**Application by Mynydd y Gwynt Ltd for an Order Granting
Development Consent for the Mynydd y Gwynt Wind Farm**

RESPONSES TO THE ExA'S SECOND WRITTEN QUESTIONS

**MYNYDD Y GWYNT LIMITED
(THE APPLICANT)**

PLANNING INSPECTORATE REFERENCE: EN010020

Figure 8.10b

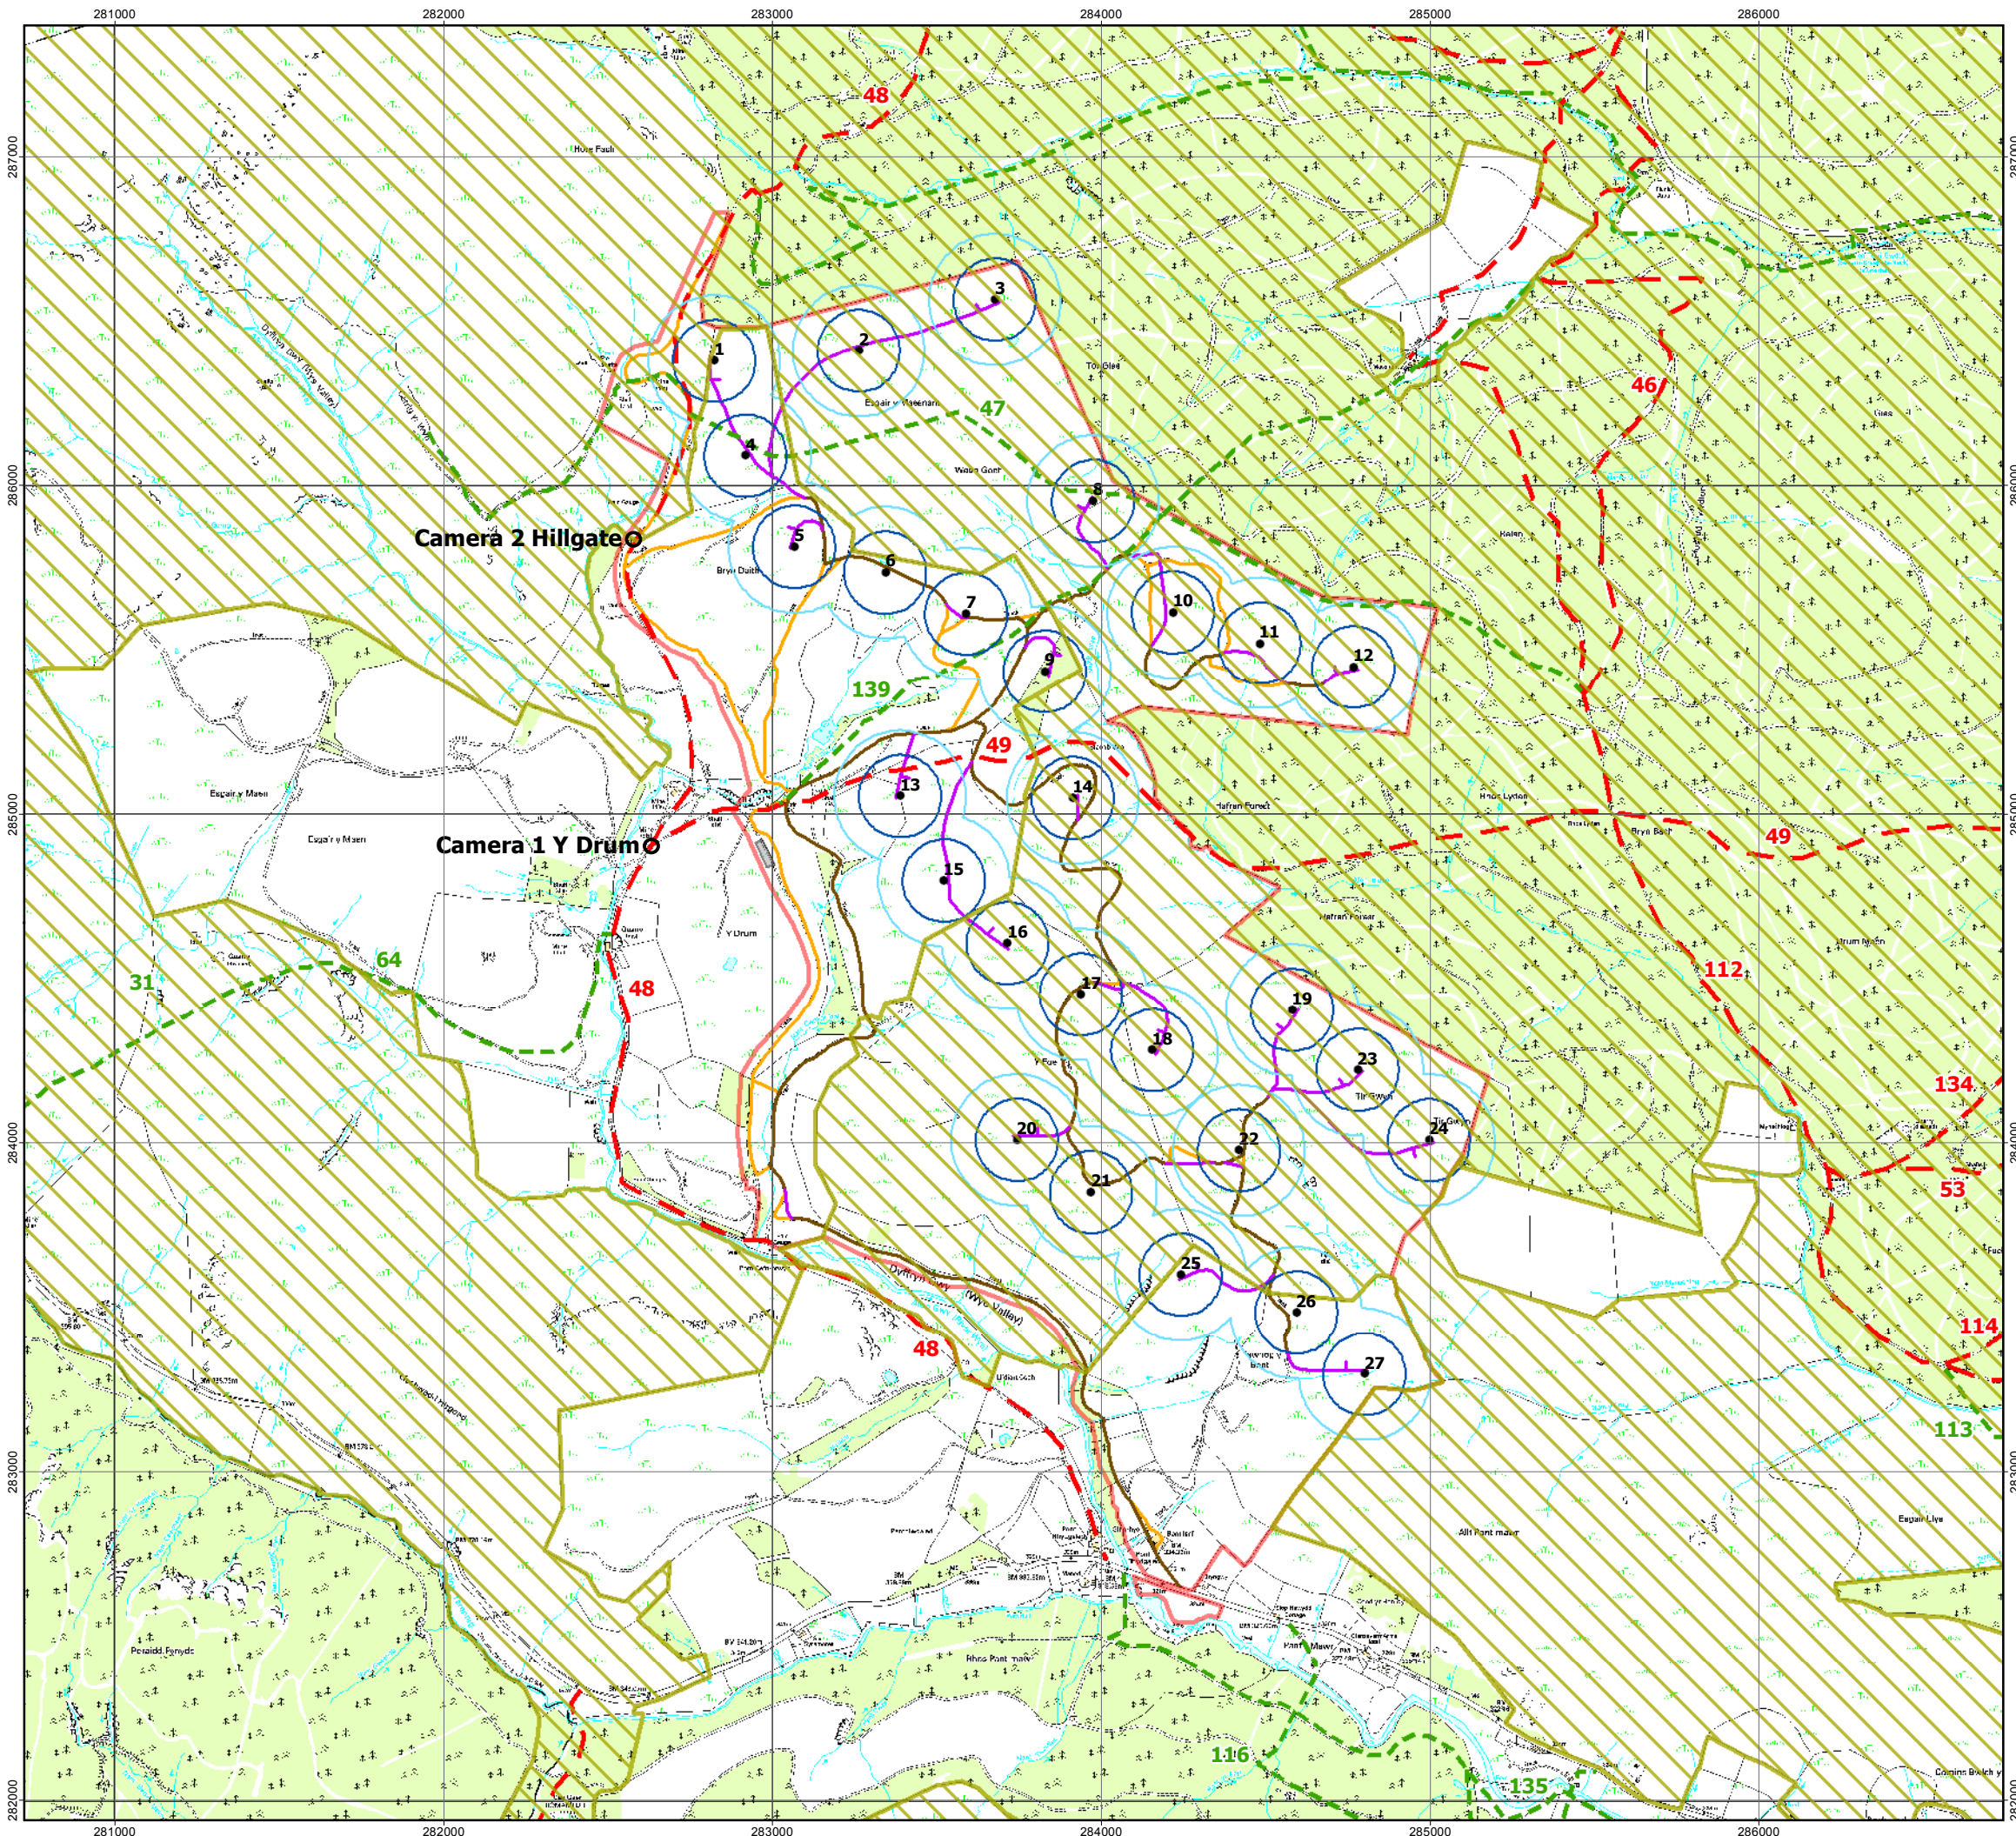
1.12	Applicant	In its Deadline III submissions (para 10.7) the applicant indicates that it would be willing to offer additional permissive rights of way where a Public Right of Way is within 125m/200m of a turbine and not already on open access land, offering the opportunity to use a different route which would not pass as close to a turbine. Could the applicant point to the location of where these might be and in relation to which proposed turbine, and also indicate the mechanism by which such permissive rights of way could be secured?	<p>Following an onsite meeting with PCC on 6 February the applicant reconsidered and revised the offer of permissive PROW and horse car park to reflect the discussions. The locations of the permissive rights are shown on the plan at Appendix 7 (Figure 8.10d) and were submitted to PCC on 11 February and included:</p> <ol style="list-style-type: none"> 1. a permissive bridleway around the track loop to the west of turbine 1. 2. a permissive footpath up the track from the bridleway to the west of T4, which then cuts back north and turns east (as agreed with PCC) to cut the middle of the gap between T1 & T4. 3. a permissive bridleway around the north of turbine 13 (keeping 125m from T13) which links to the track and then permissive options that either continue on the track round T14 or go cross country south to keep away from T14 and then follow the ridgeline down towards the Afon Bidno valley bridleway BW49. <p>The applicant has sought to finalise the location of the permissive rights of way with PCC, but PCC responded at 4.55pm on 4th March 2015 that their comments will appear in their answers to these questions.</p>

The applicant intends to secure the permissive rights of way by of a requirement in the DCO.
2.0	Landscape and visual		
2.1	Applicant	CCC in its LIR indicates at para 4.34 that the applicant's LVIA categorises significant effects as only those over 'moderate to substantial' and above. This means that effects such as 'moderate' or 'moderate/moderate to substantial' significance are not considered significant. CCC goes on to suggest that whilst this is often used for wind farm developments, it is not consistent with most LVIAs for other developments where 'moderate' is considered to be the normal threshold for significance. Can the applicant please comment on this?	<p>The approach taken in the LVIA and all subsequent considerations to the reporting of significant effects is fully consistent with current best practice. GLVIA3 records in paras 3.32 onwards that: The Regulations require that a final judgement is made about whether or not each effect is likely to be significant. The guidance set out in this section does not state that an empirical measure must be used, but that LVIAs should always distinguish clearly between what are considered to be the significant and non-significant effects. The guidance goes on to state in paragraph 3.34 that: When drawing a distinction between levels of significance is required (beyond significant/not significant) a word scale for degrees of significance can be used (for example a four-point scale of major/moderate/minor/negligible).</p> <p>CCC state that it is not consistent with most LVIAs for other developments where 'moderate' is considered to be the normal threshold for significance. However, for wind farms it is considered</p>

Figure 11.16

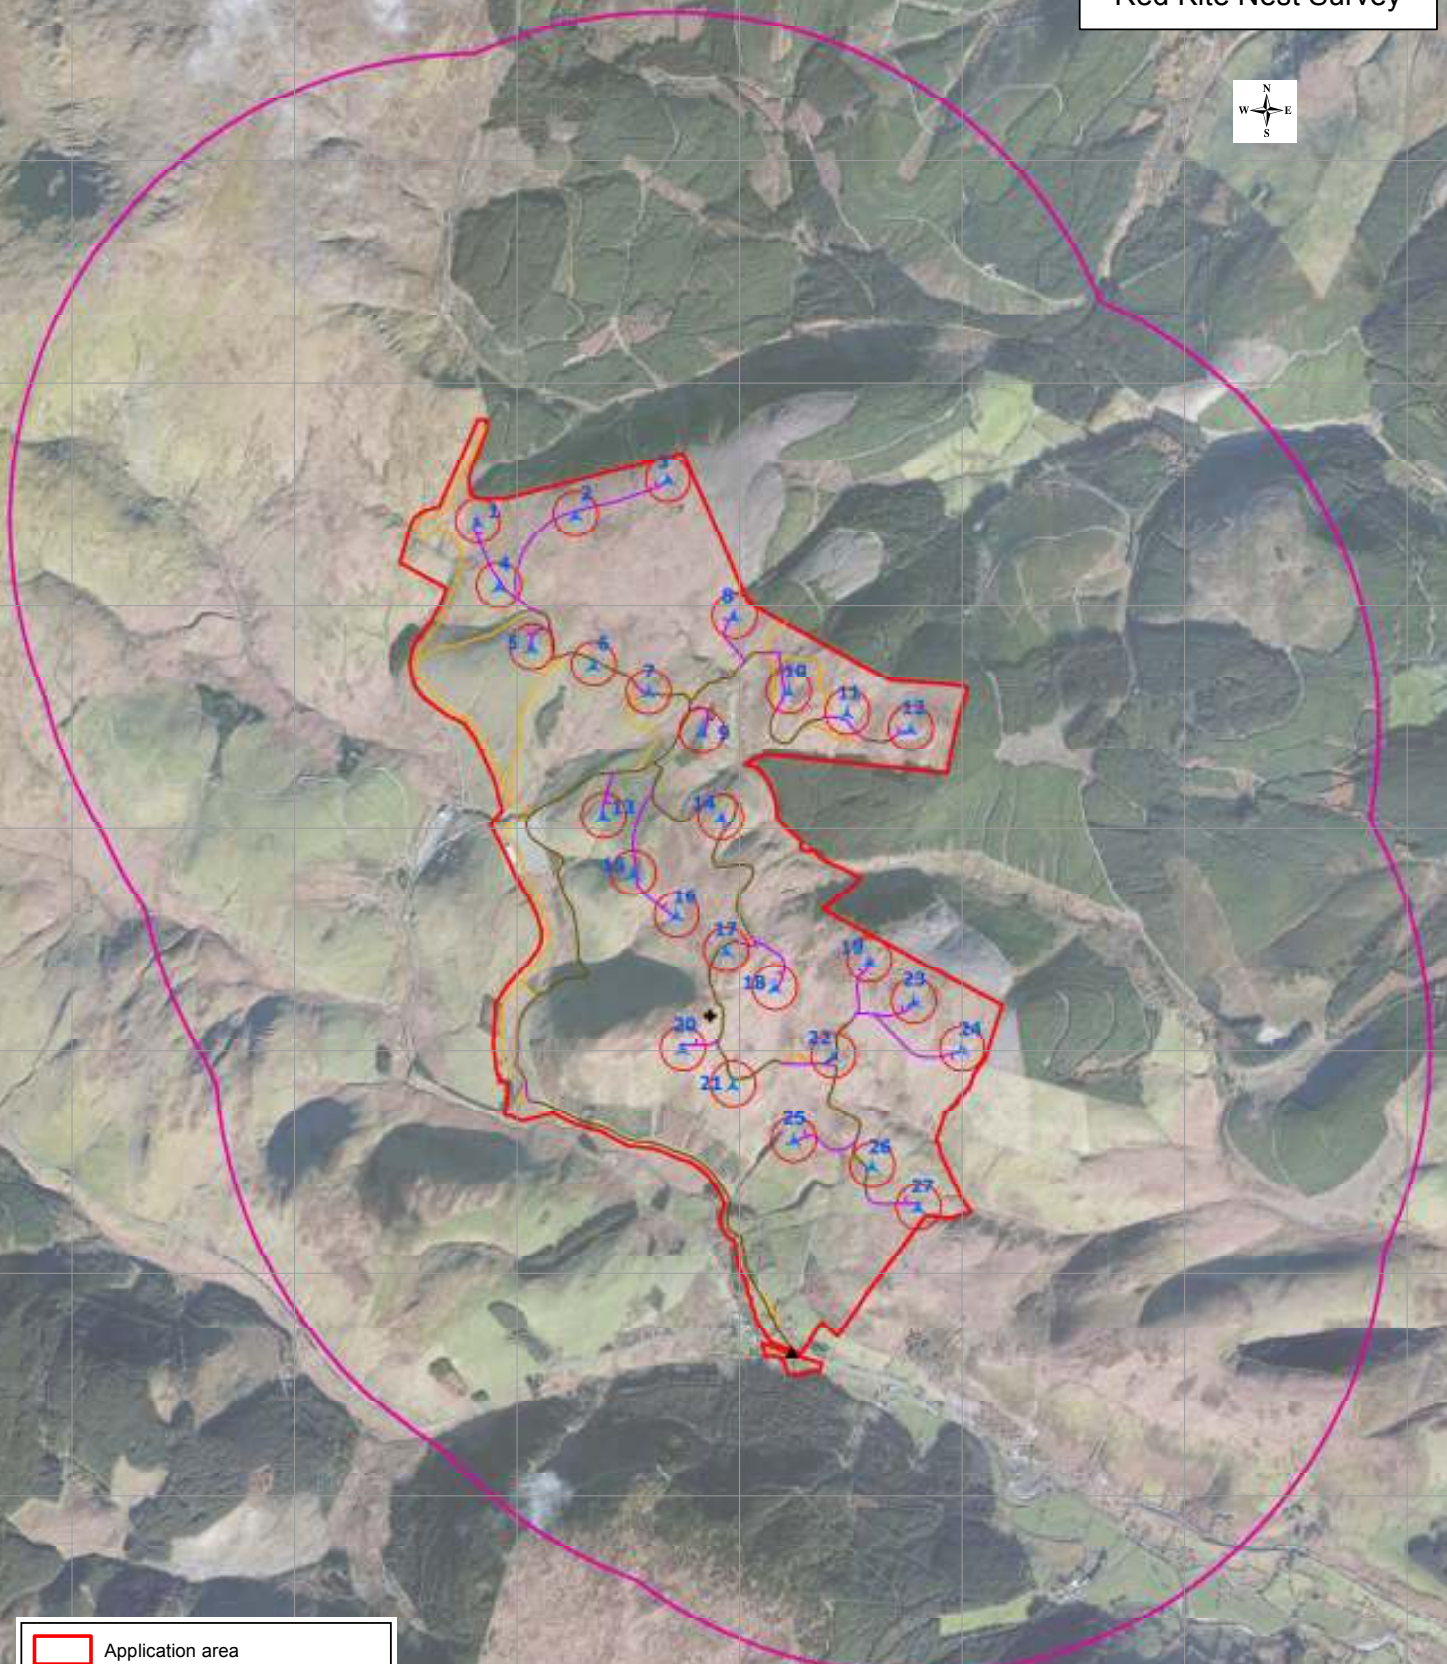
4.17	Applicant	Paragraph 5.23 of the applicant's comments submitted for Deadline III, refer to a Red Kite nest survey that was undertaken between March and July 2014. Please could the applicant provide a copy of the survey report, and state whether or how these findings affect the impact assessments in the ES Ecology chapter and the HRA? In the event that they do, an updated impact assessment will need to be provided.	A nest survey has been attached as Appendix 17 . As no nests were found there has been no effect on the impact assessments in the ES Ecology chapter (chapter 11) or the HRA.
